From: [REDACTED]
Sent: 24 June 2019 18:07
To: Sian Eggington
Subject: Re: FINAL REMINDER AB/46/19/HH 17 Stewarts Rise

Our description based on your plans is 'Single storey front/side/rear extension and porch to front, addition of a dormer to create additional habitable roof space and landscaping to create an additional (?) parking spaces' Please confirm you agree with our description and with your permission we can amend the form for you.

17SREXPRK2018-R02
 17 Stewards Rise - Arundel
 Existing Roof Plan
 & Car Parking
 Scale 1:200 @ A4 (2018)

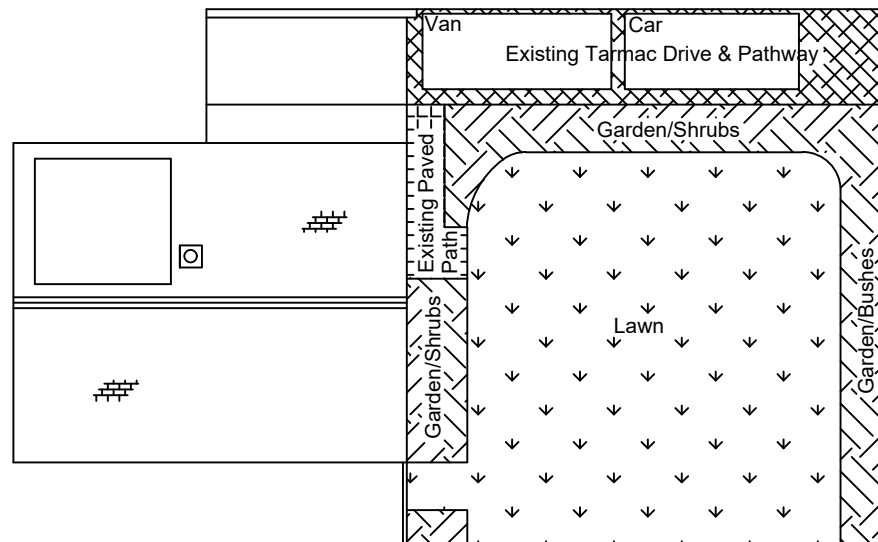
Parking: Your forms state that you are providing an additional 2 parking spaces however the plans are showing an additional 4 spaces. Please confirm which is correct and amend your form as necessary.

Please see attached pdf Arundel 2018 existing-17SREXPRK2018-R02 in which I have removed the hatch from the indicative car and van. I think it was not very clear on the original submission which indicates that there is already parking for 2 vehicles. The proposed would allow for 2 additional.
